# CITY OF ALBUQUERQUE

August 11, 2023

**Re: Fiesta Subaru**  
**7100 Lomas Blvd. NE**  
**30-Day Temporary Certificate of Occupancy**  
**Transportation Development Final Inspection**  
Architect's Stamp dated 04-28-22 (K19-D108A)  
Certification dated 06-30-23

A1 SITE PLAN

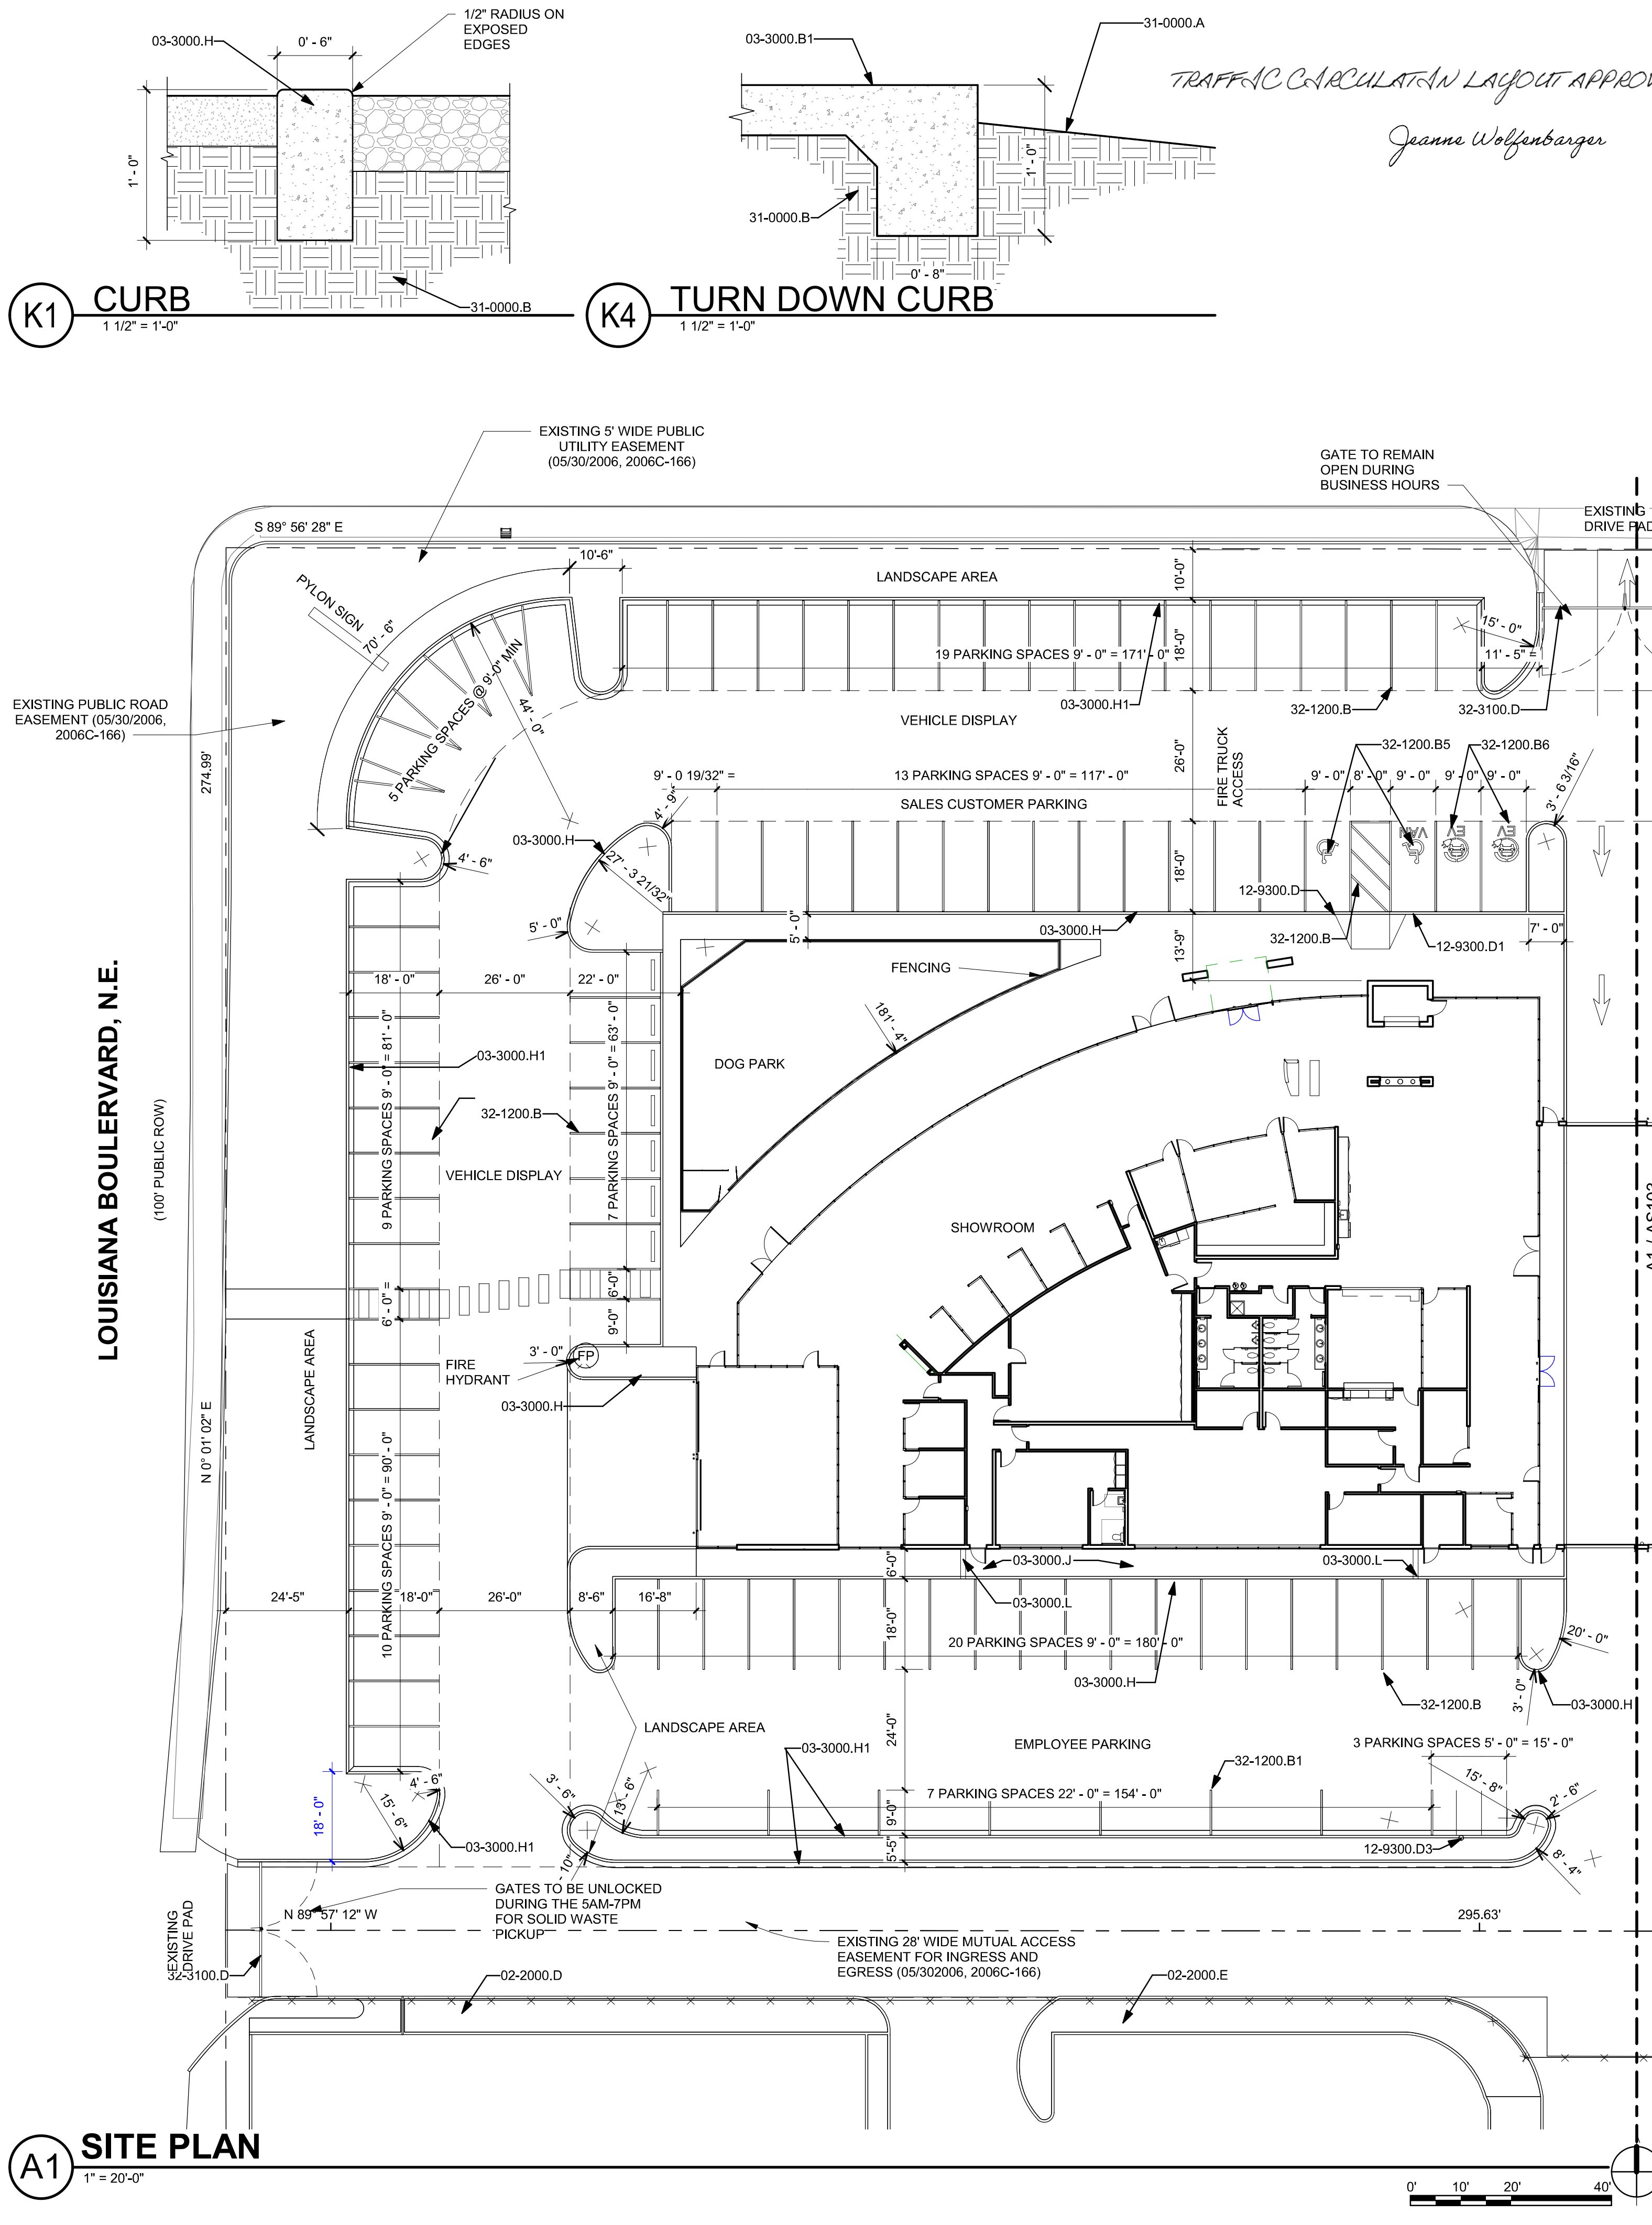
Prior to the issuance of a permanent Certificate of Occupancy, the following items must be addressed: **please address all Ernest Armijo's previous comments.**

- Per approved site plan, please provide an ADA pathway connection in the southwest entrance. Either reconstruct to add accessible ramps the same as the other entrances or add an ADA accessible path along the back of the drive ramp.
- Per approved site plan, please provide an ADA pathway connection in the southwest entrance. Either reconstruct to add accessible ramps the same as the other entrances or add an ADA accessible path along the back of the drive ramp.
